STAGE 1 ROAD SAFETY AUDIT

RESIDENTIAL DEVELOPMENT, WHITEHALL ROAD WEST, BIRKENSHAW

DESIGNER'S RESPONSE

ISLAND DETAIL
Scale 1:100

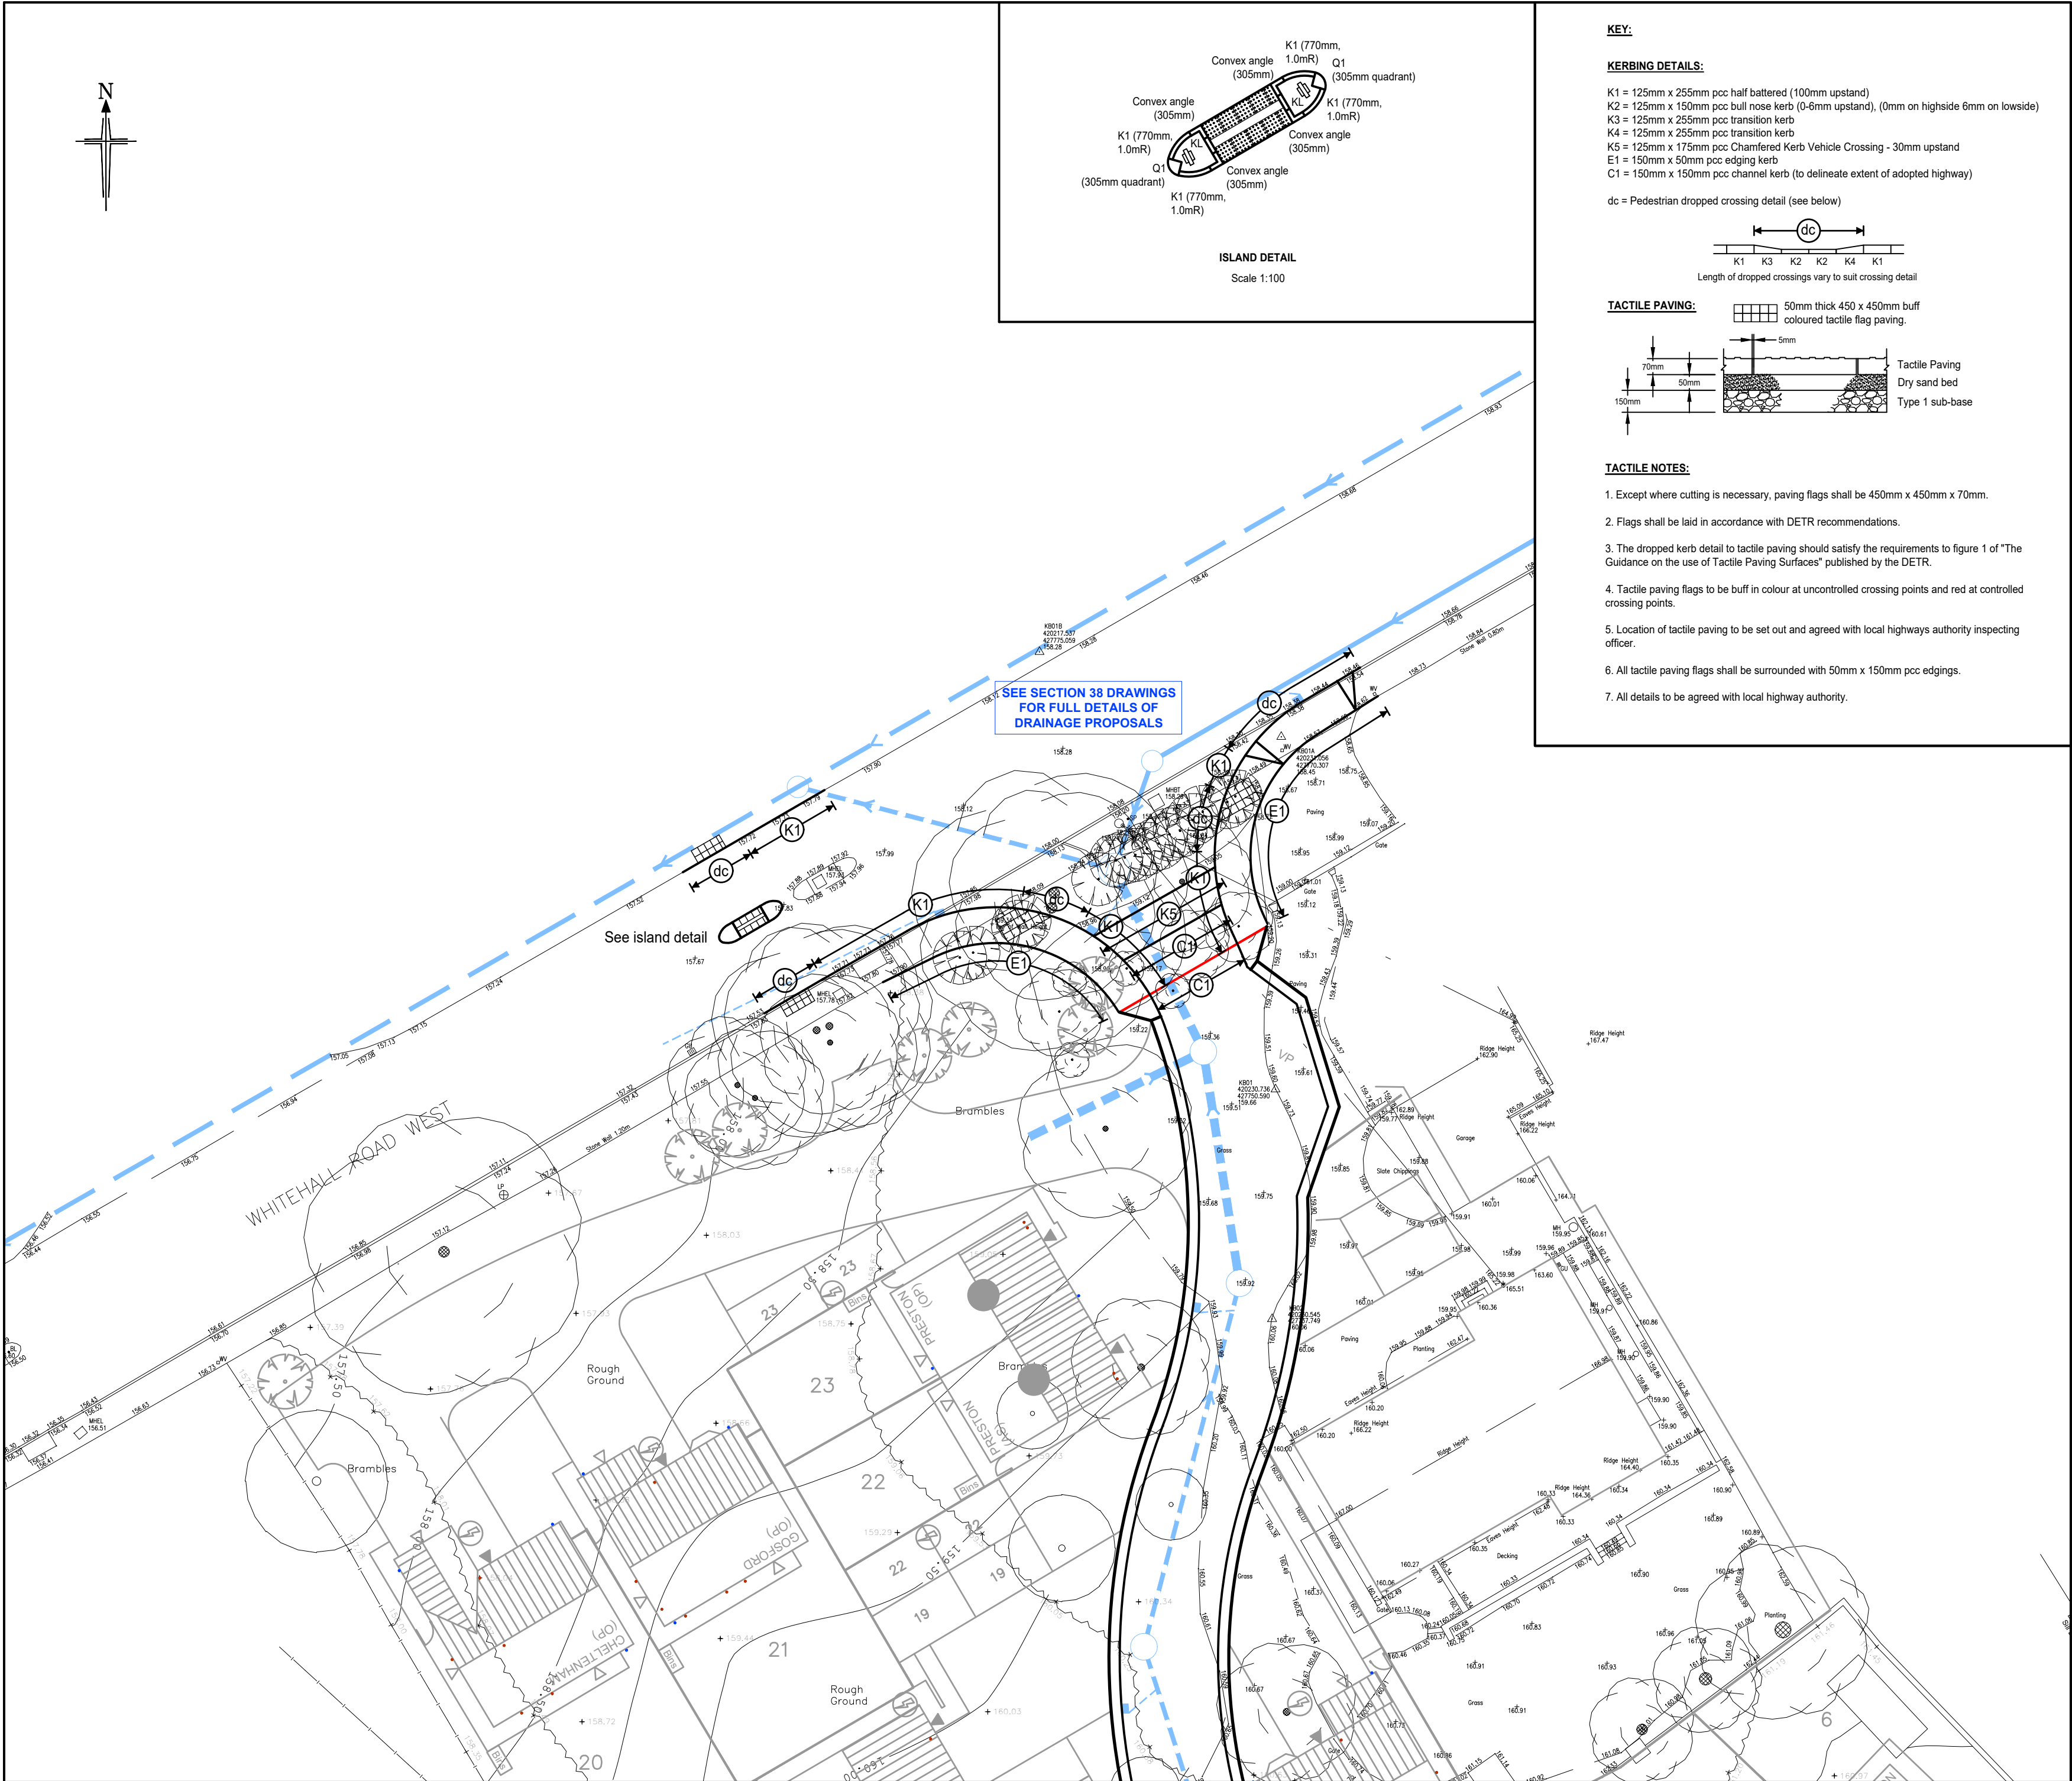
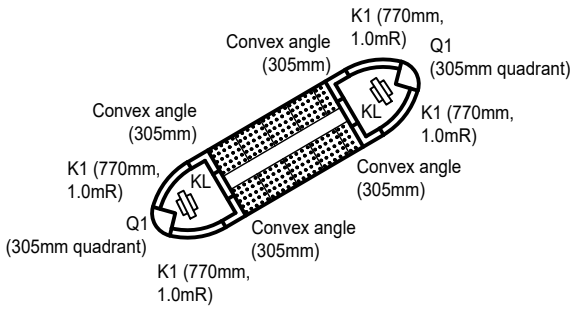
RSA Problem	RSA Recommendation	Design Organisation Response	Overseeing Organisation Response	Agreed RSA Action
PROBLEM A Relocated uncontrolled crossing Whitehall Road. Summary Pedestrian refuge islands that do not provide sufficient width will increase the risk of pedestrian/vehicle collisions. It is proposed to relocate the existing uncontrolled crossing and central refuge to the south of the new access. The Audit Team noted that the pedestrian refuge is very narrow 1.2m. It is generally recognised the minimum width should be no smaller than 1.5m. Pedestrian refuge islands that do not provide sufficient width will increase the risk of pedestrian/vehicle collisions.	The Audit Team accept that this is an existing refuge and that it will simply be relocated like for like. However, the Audit Team still recommend that the size of the refuge is increased to 1.5m where possible.	There are 3 traffic islands on Whitehall Road between the proposed site access and the roundabout with Heathfield Lane providing uncontrolled pedestrian crossing points across Whitehall Road West. Each island is approximately 1.0m wide. The Designer acknowledges the current width of the traffic island, but that any increased island width would be provided on the balance of providing a bit more width for the occasional pedestrian standing in the middle of the carriageway crossing Whitehall Road West or reducing the available lane/carriageway width between the new island and kerb edge and therefore increasing the risk of side swipe type accidents between vehicles and cyclists passing the island at the same time.

On balance the Designer believes the width of the relocated/new island should be increased but to a maximum width of 1.20m. Refer to drawing 23/341/SK/003 rev B for details.		
PROBLEM B Access junction Whitehall Road. Summary Blocking back of traffic over the access could increase the risk of shunt and failure to give way type collisions. The Audit Team noted that traffic can queue back along Whitehall Road between the Heathfield Lane roundabout and the Birkenshaw Roundabout depending on time of day. This could lead to driver frustration especially when turning out of the development leading to drivers taking unacceptable risks increasing the risk of shunt and failure to give way type collisions.	It is recommended that “Keep Clear” markings are considered on Whitehall Road so that when traffic slows and begins to queue vehicles on Whitehall Road will give way.	Agreed. KEEP CLEAR road marking will be added to the proposed access arrangements. Refer to drawing 23/341/SK/003 rev B for details.
